From: Clare Dales
Sent: 28 February 2018 14:24
To: Richard Temple
Subject: RE: Planning Consultation on: FP/7/18/L

APPLICATION FP/7/18/L

Site Address: Richmond House 47A Felpham Way Felpham PO22 8PT

Description of Works: Listed Building Consent for proposed side extension to non original part of dwelling

Itemref	Quantity	Title/Name, designation, material, dimension etc	Article No./Reference
Designed by	Checked by	Approved by - date	Date
JD		January 2018	1/50

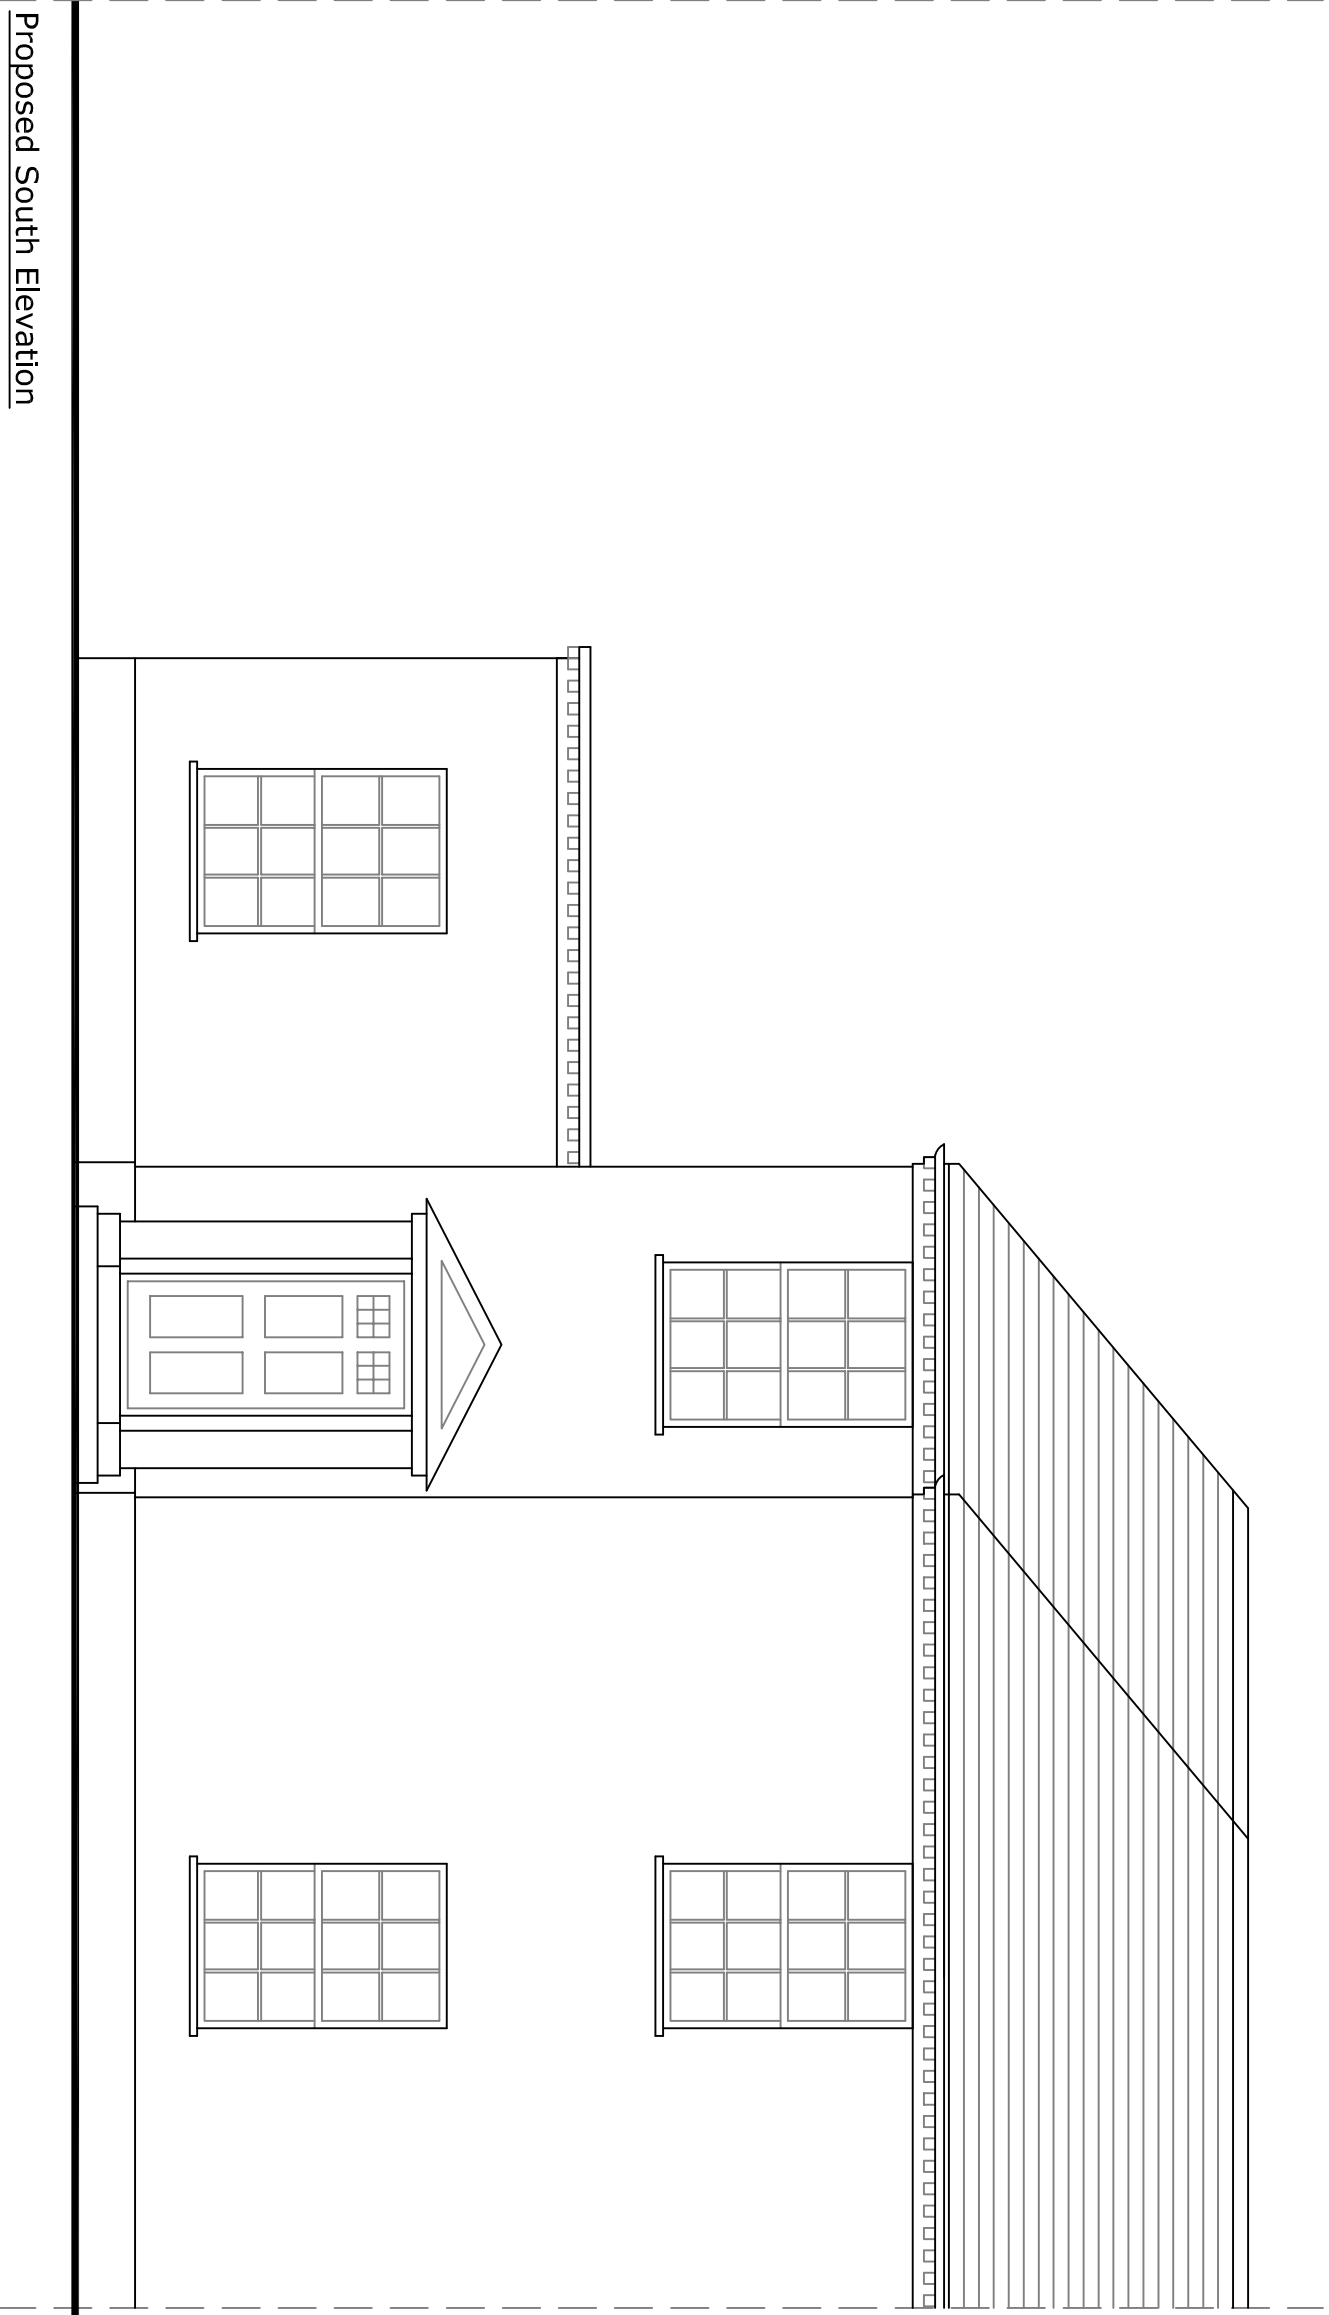
The submitted plans detail an extension, plus a solid wall with door and canopy over. The proposed extension to kitchen is supported in terms of scale, mass, location and detailing, with the exception of the bifold doors as shown on plan. Such glazing is considered out of keeping with the property. It is recommended that a single solid/cottage door be inserted within a solid wall. Fenestration may be introduced.

The solid, freestanding wall with door and canopy is recommended for refusal as this element is dominating, detracts from the main house, its existing (and proposed extension, if approved).

It is noted that the existing and proposed pedestrian and vehicular gates are shown identically. The existing gate as seen during a site visit does not match that drawn, nor would approval be recommended, due to the solid nature of the proposed, and their overly contemporary styling.
